21 February, 2018

RE: PROPOSED REDEVELOPMENT OF COCKLE BAY WHARF

1. As requested, we have reviewed the traffic matters raised by RMS, TfNSW and City of Sydney with respect to the above development. Our response is set out in the attached table.
2. We prepared the traffic report that accompanied the SSDA for the above development (Traffic Report for Revised Proposed Development of Cockle Bay Park, Darling Harbour – September 2017).
3. In summary the matters raised by RMS, TfNSW and City of Sydney can be addressed through conditions, amendments to the scheme or provision of additional information as part of a Stage 2 DA.
4. We trust this document provides the information you require. If you should have any queries, please do not hesitate to contact us.

ATTACHMENT B  
VEHICLE TURN PATHS

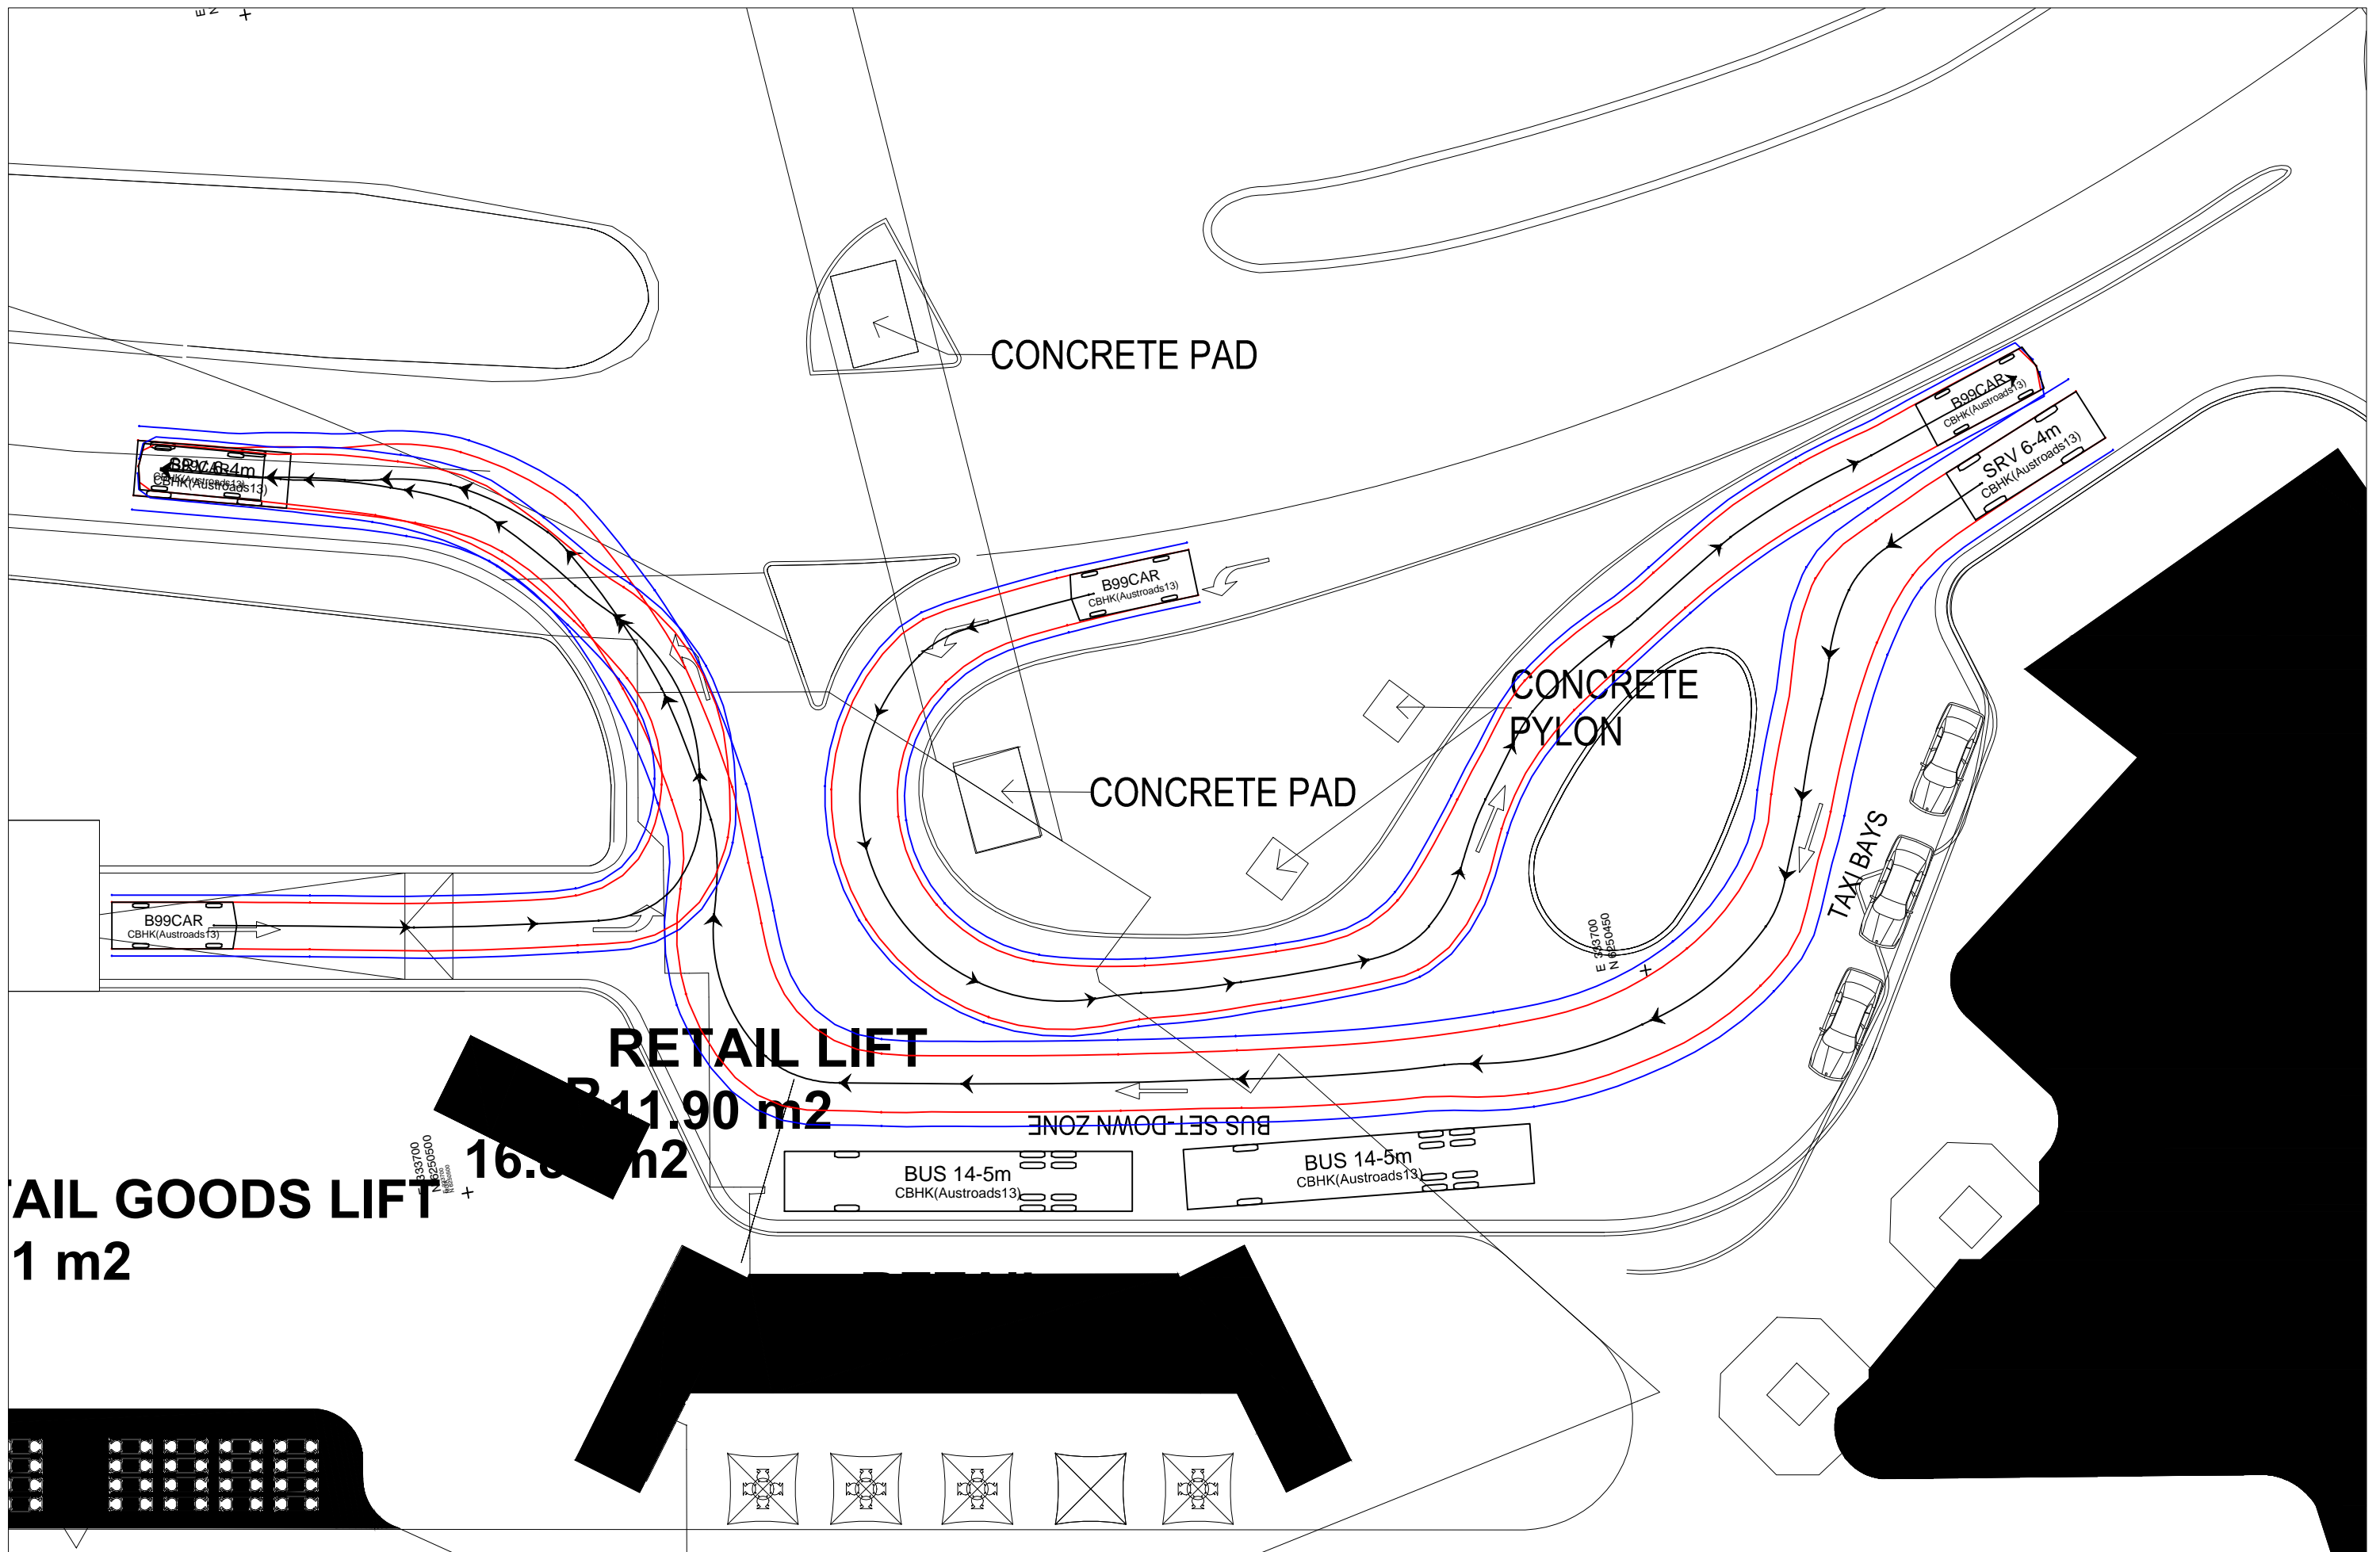
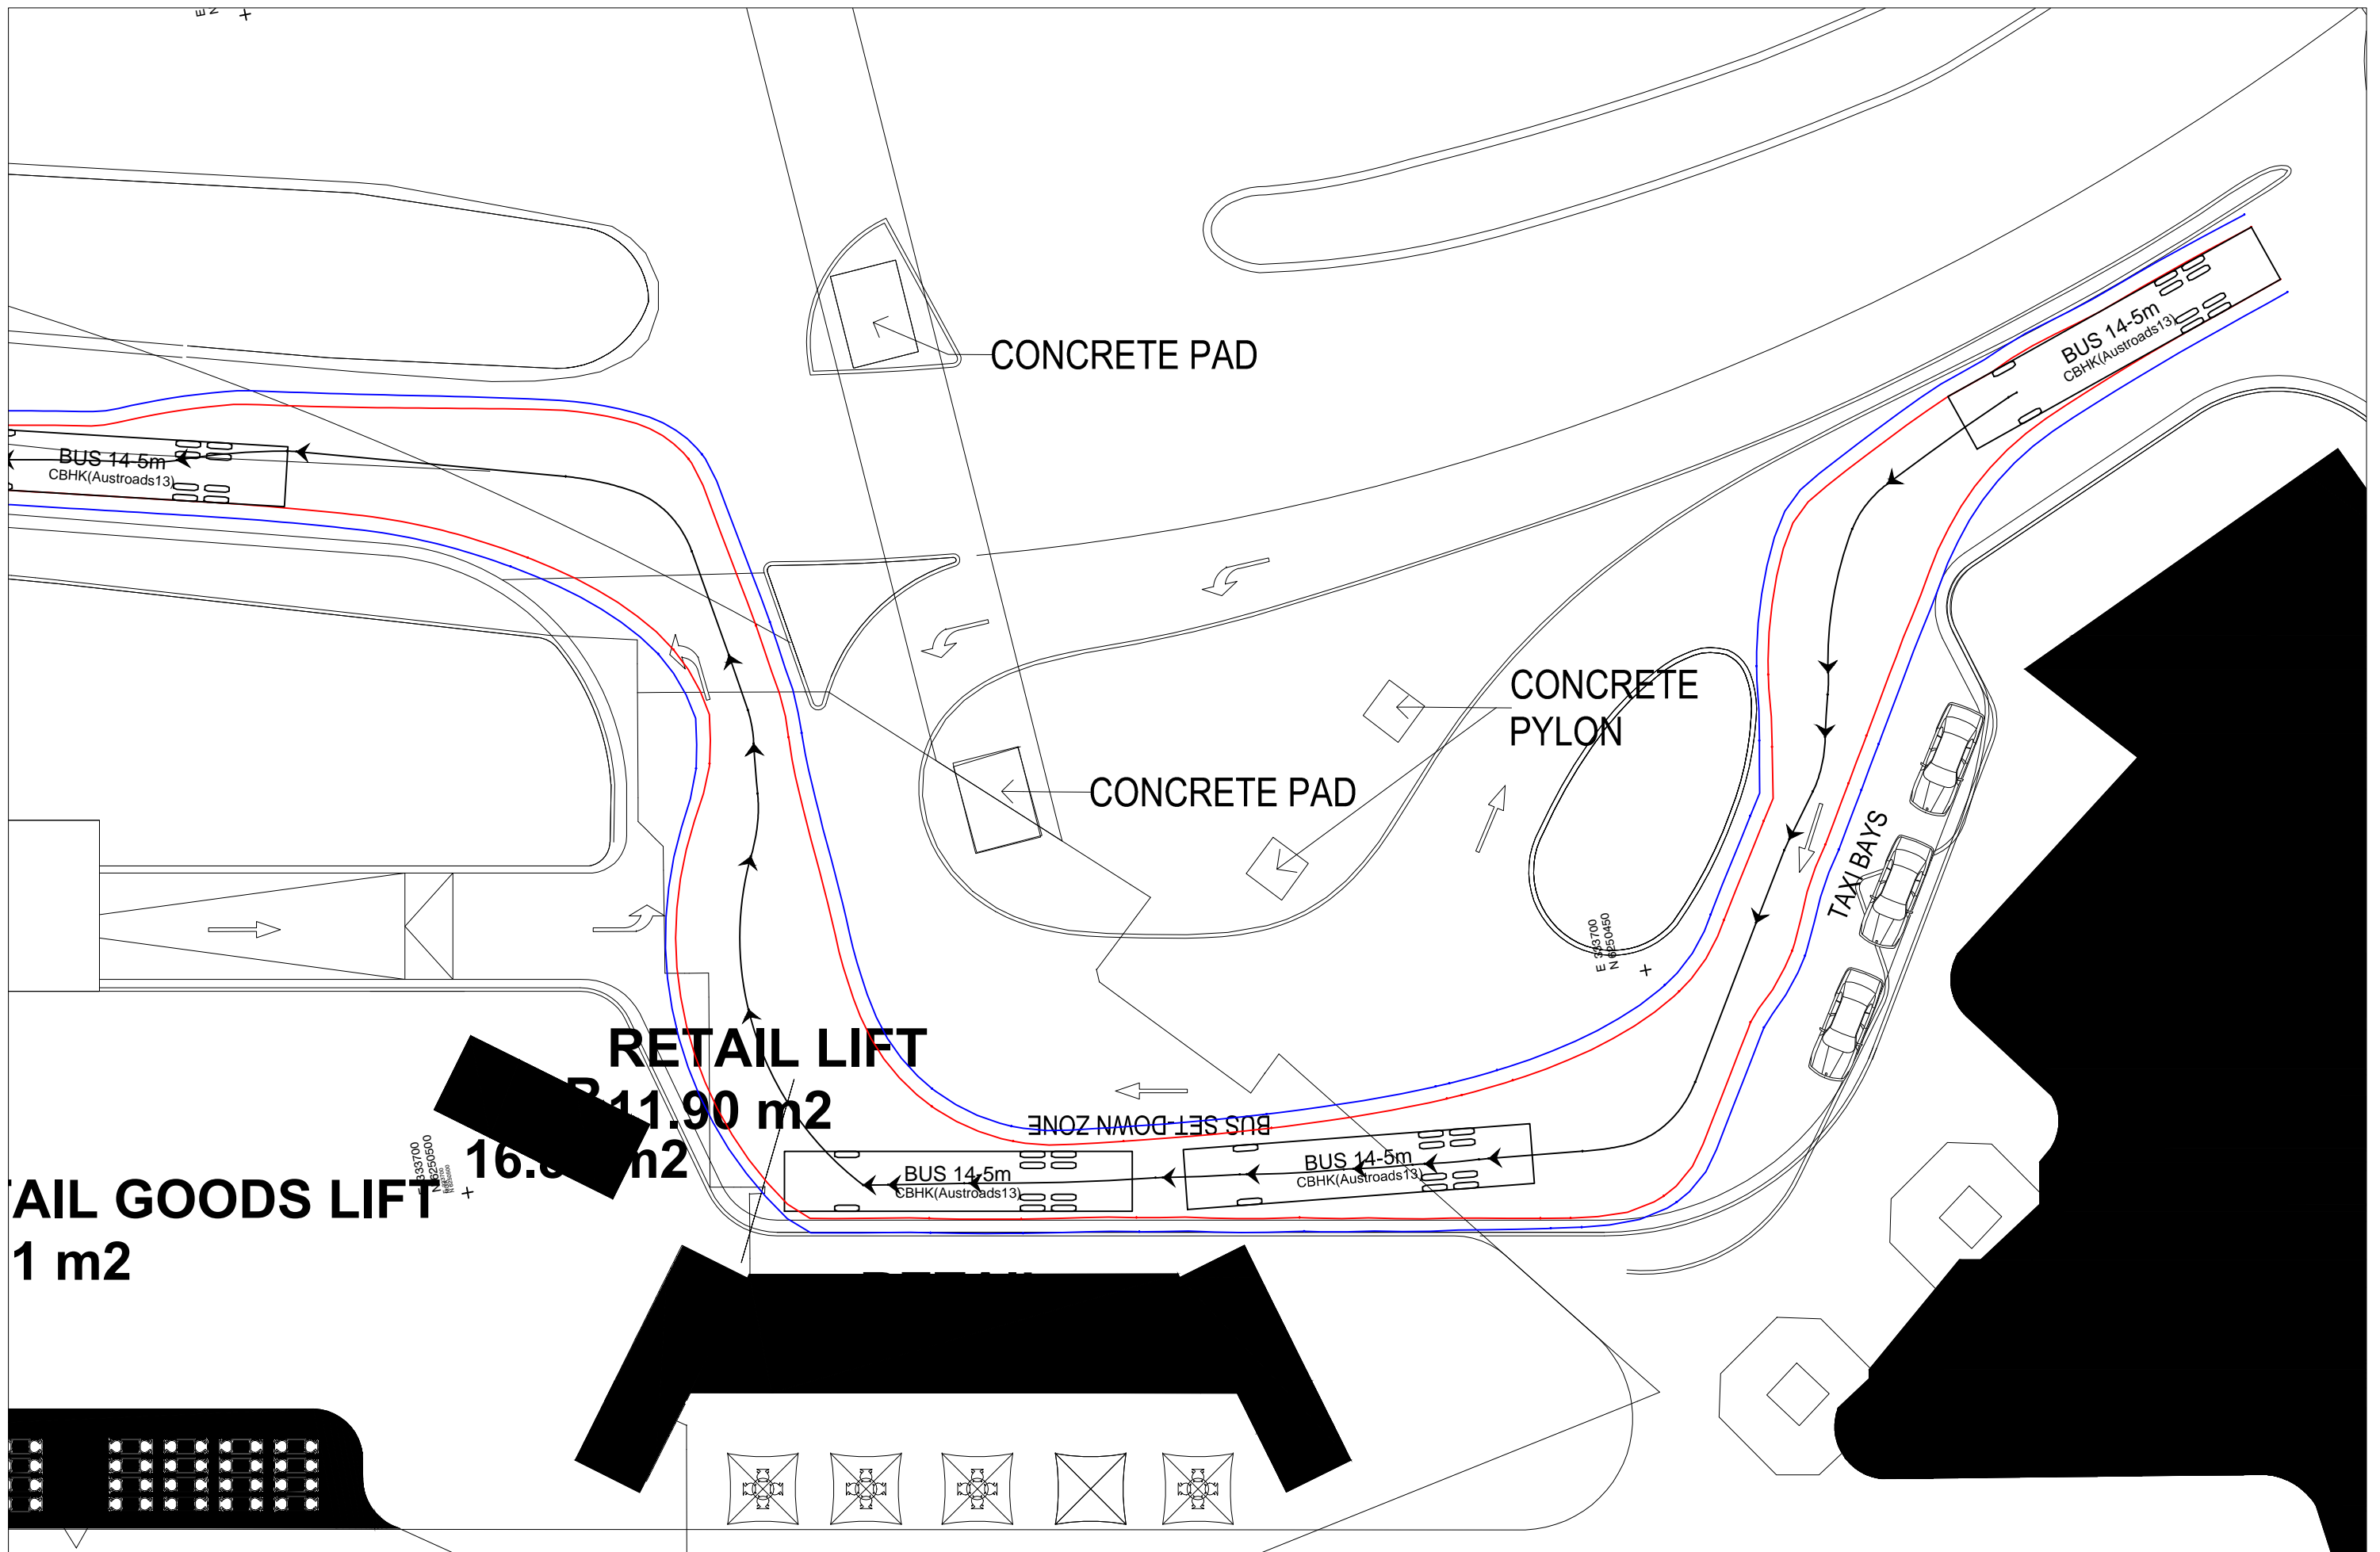
Provision of truck paths into/out of the site and on Wheat Road	Truck paths were provided in our traffic report (Attachment B). Updated truck paths will be provided in a Stage 2 DA.
Car park entry to the new car park requires 2 way access out of the Ribbon development which is not possible	Modifications to the Ribbon development were identified to provide 2-way access and address the matters raised by CoS. Notwithstanding this, as RMS has not supported the signalised right turn from Wheat Road onto Harbour Street, the connection from the Ribbon development onto Wheat Road will remain one-way.
Concern about the operation of the southern connection from Wheat Road to Harbour Street, in particular the proposed signalised right turn onto Harbour Street	As noted above the RMS does not support the proposed right turn egress but does not object to a priority controlled left turn egress.
CoS requests detailed information on the operation of proposed porte cochere located at the northern end of the site to demonstrate that it does not impact on the through traffic travelling north of the site	The concept plans show parking for 7 vehicles in the northern porte cochere with additional queuing available. This is an improvement over the existing situation. A more detailed assessment will be undertaken as part of a Stage 2 DA.
